DRB CASE ACTION LOG (FINAL PLAT)

DRB Application No.: 05DRB-00306 (FP)
Project Name: BLACK FARMS ESTATES U 1/2
Agent: Tierra West LLC

RE: Black Farms Estates, Units 1 & 2/final plat

**PLAT OF
 BLACK FARM ESTATES
 UNIT 1**

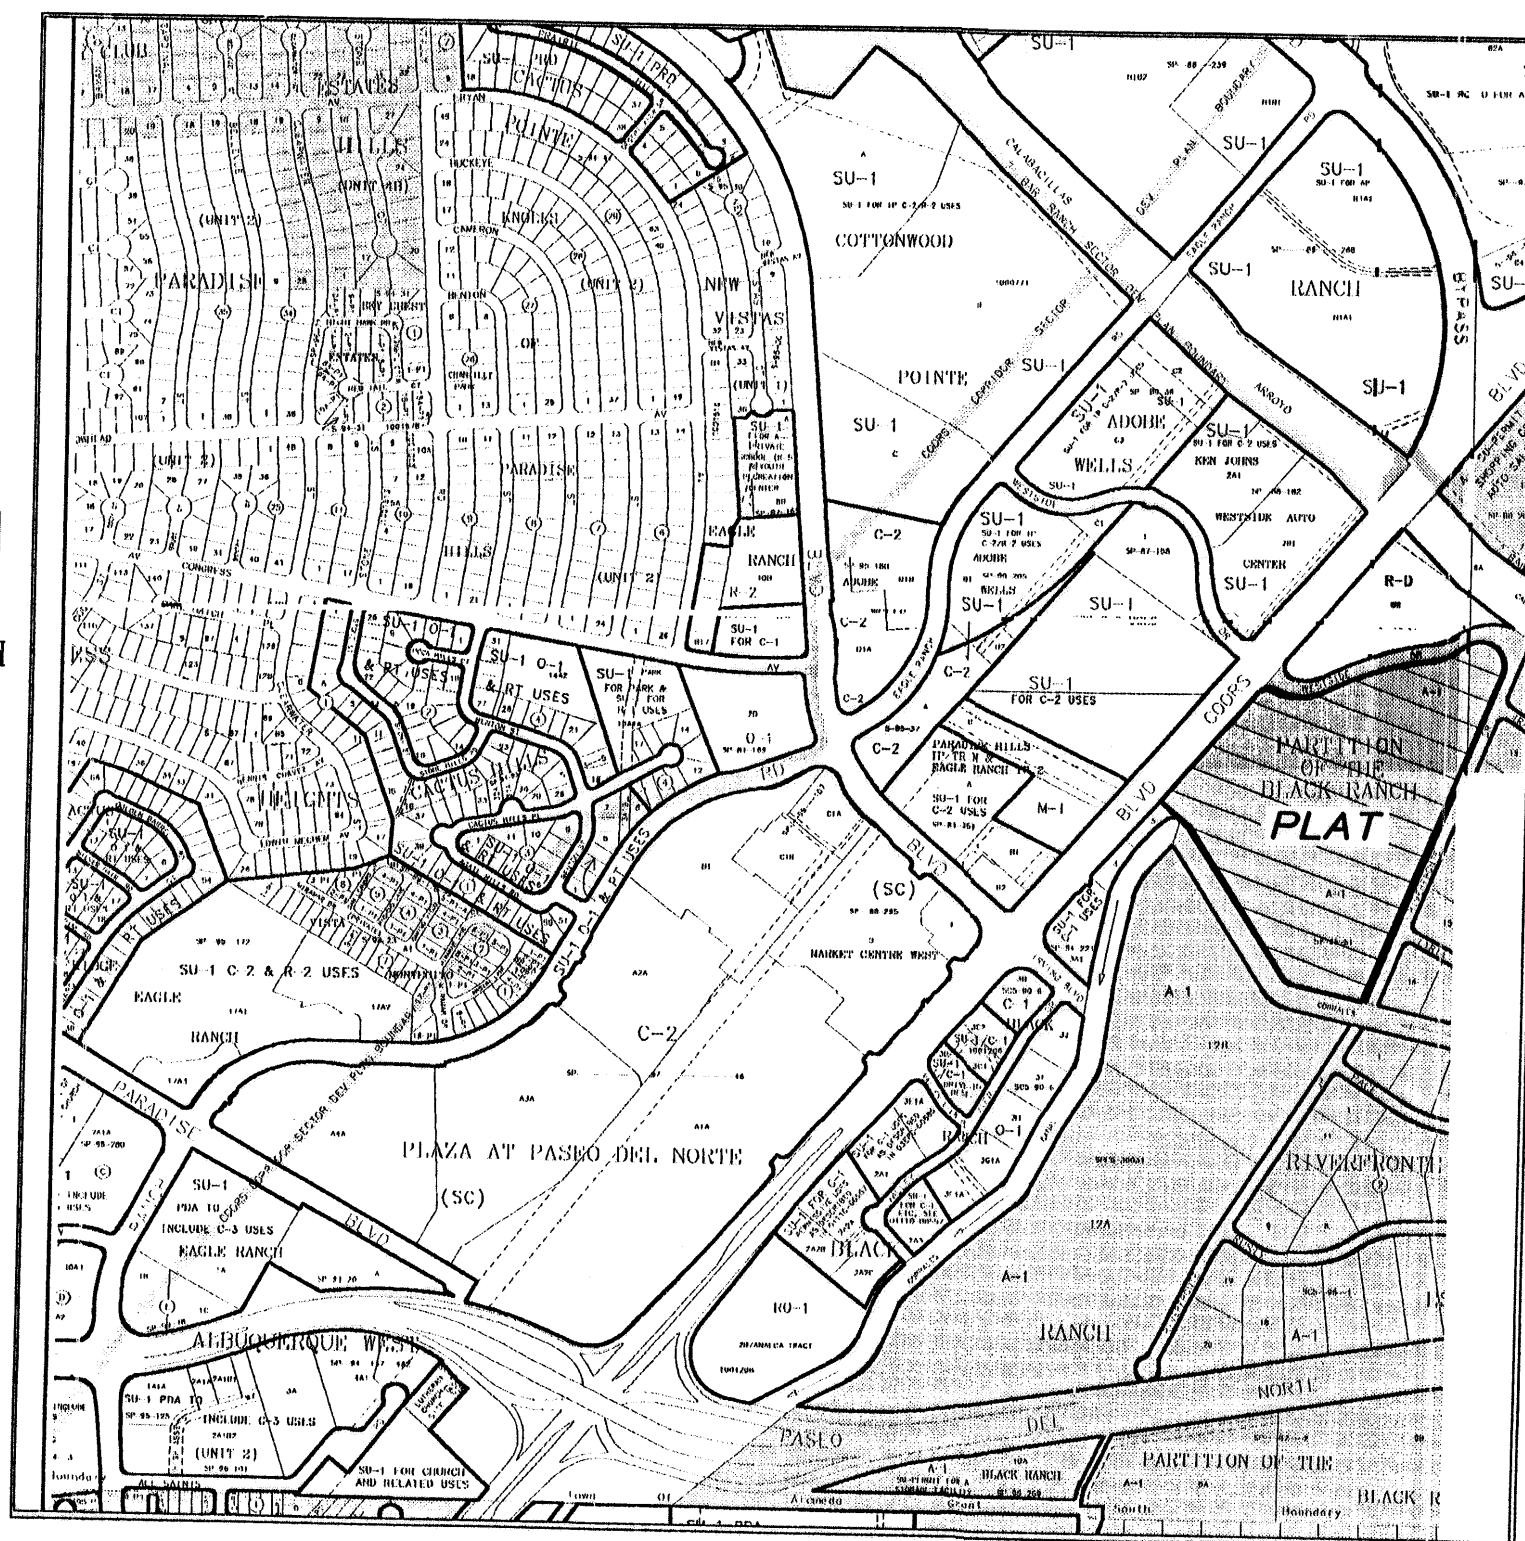
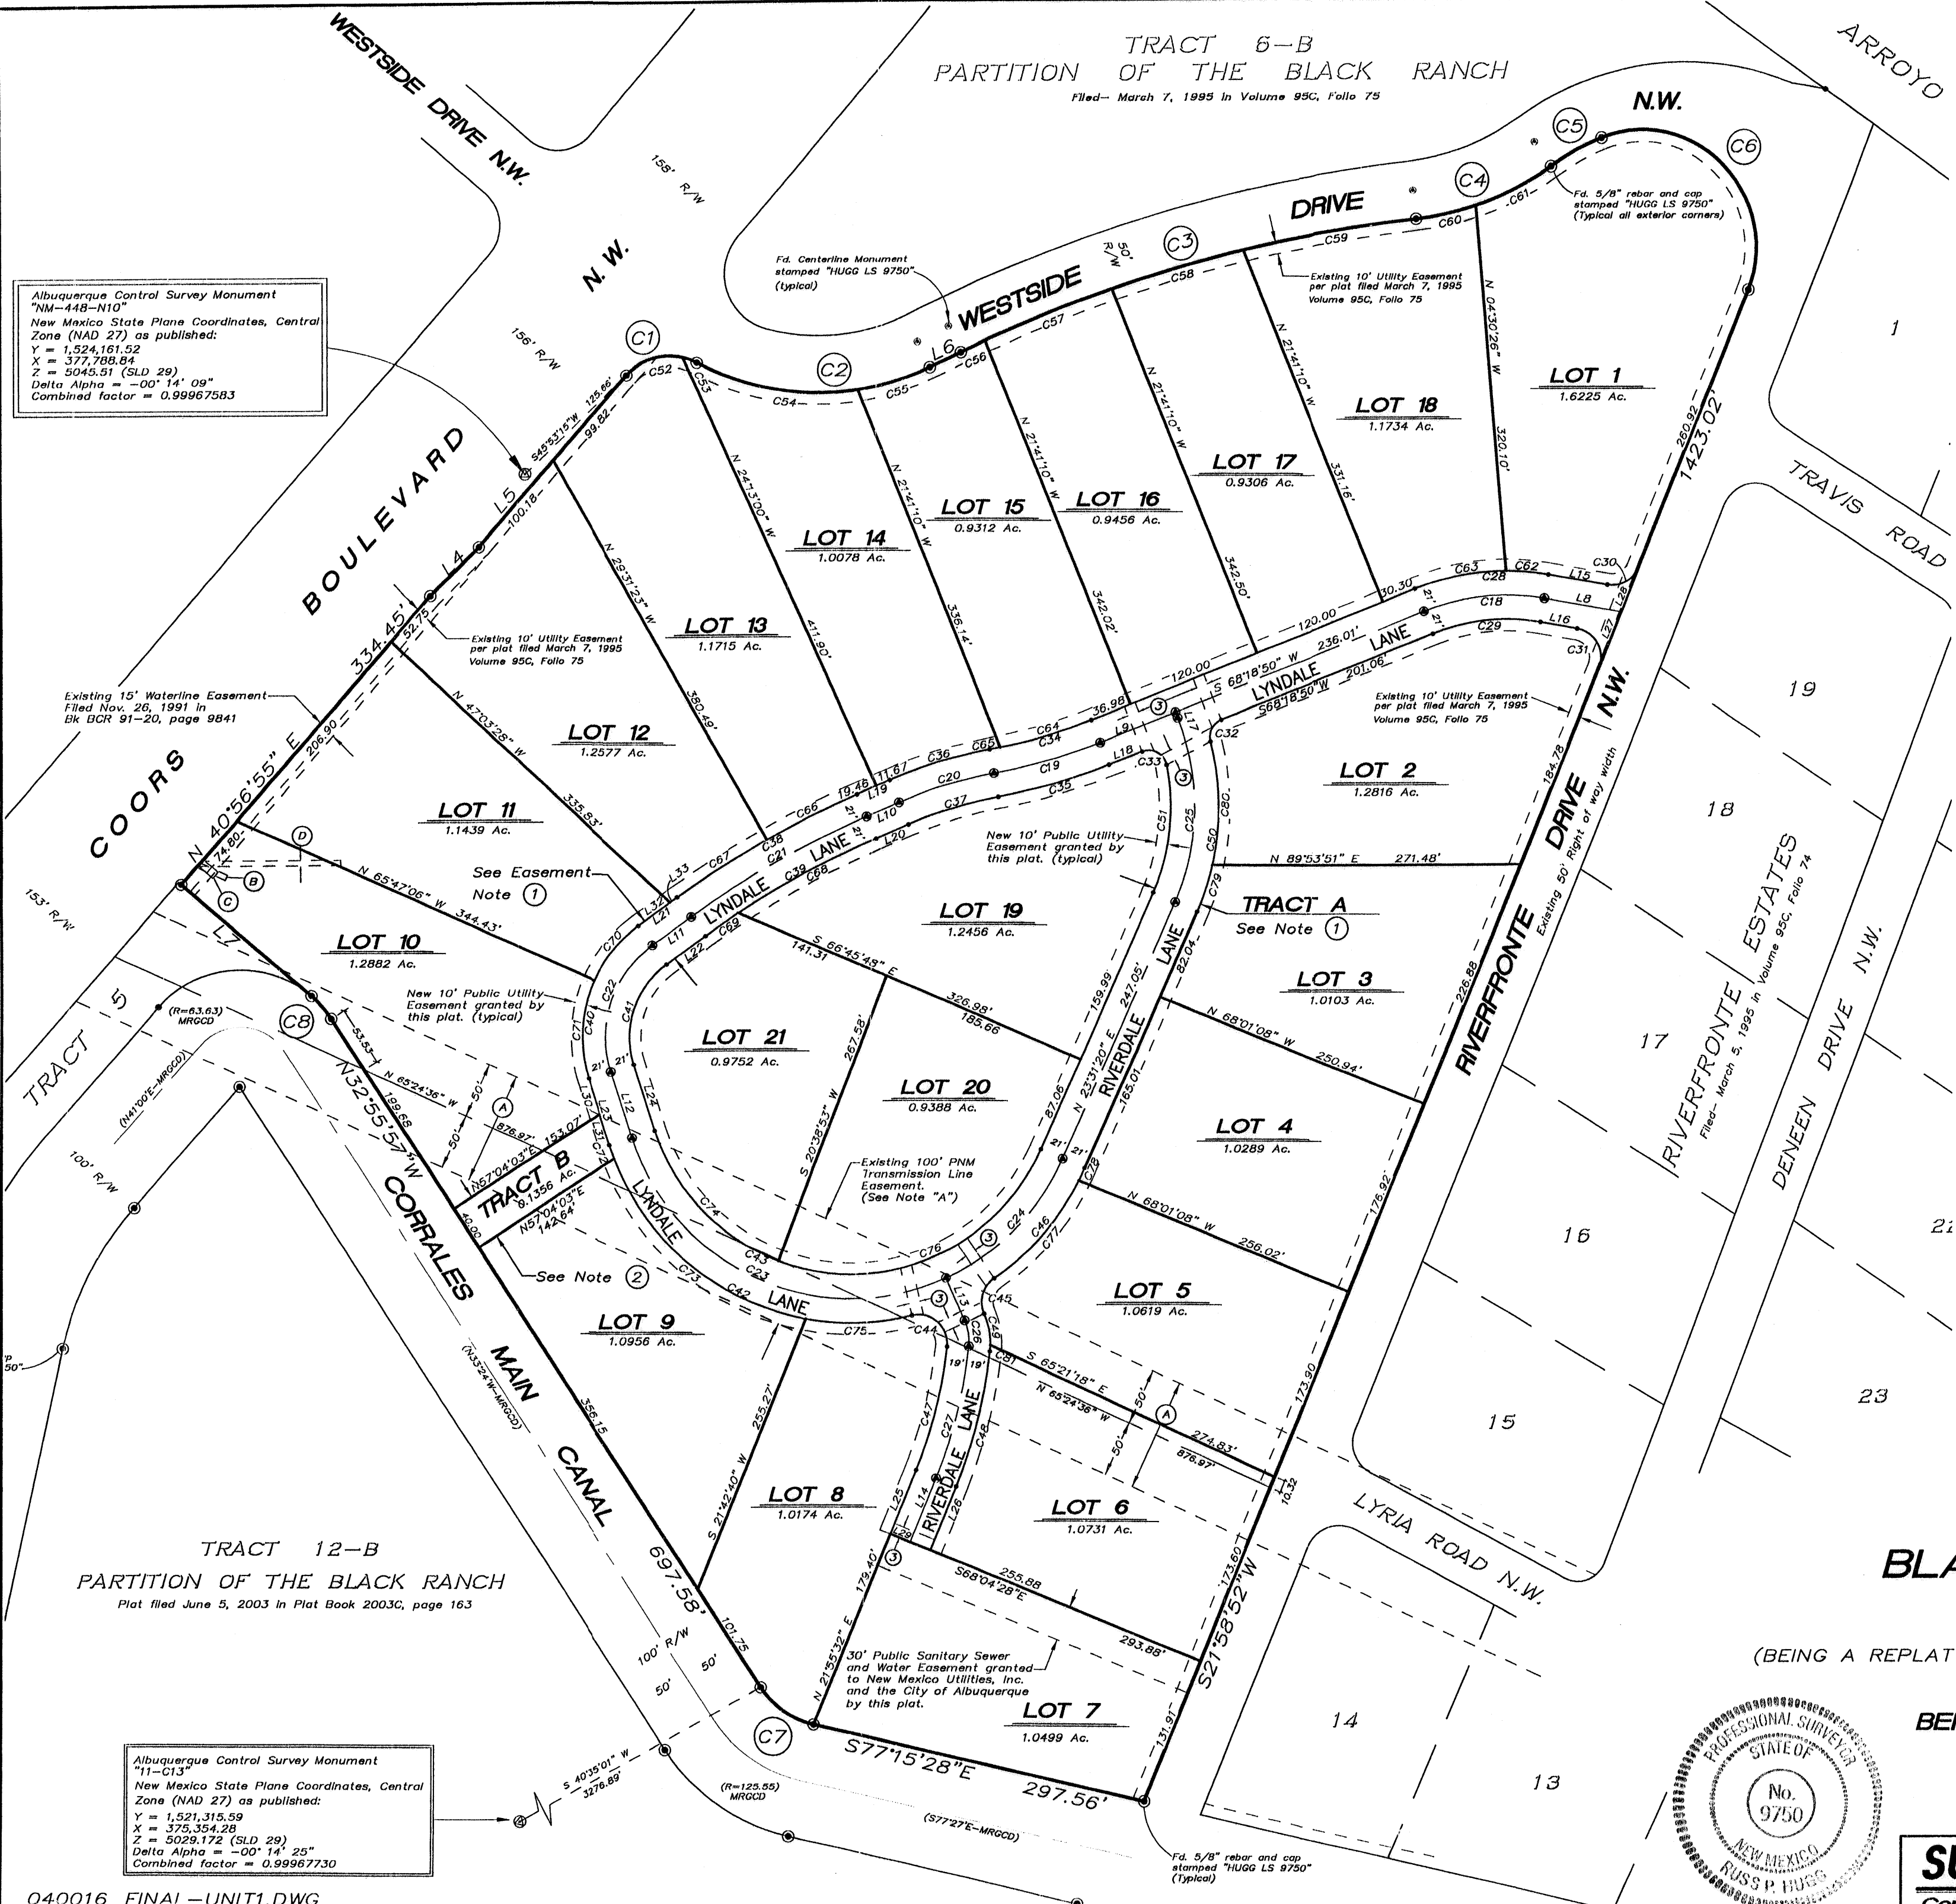
Add the following note to the plat. All open space requirements are met on the lot with the dwelling per the provisions of Section 14-16-3-8 (A) (1).
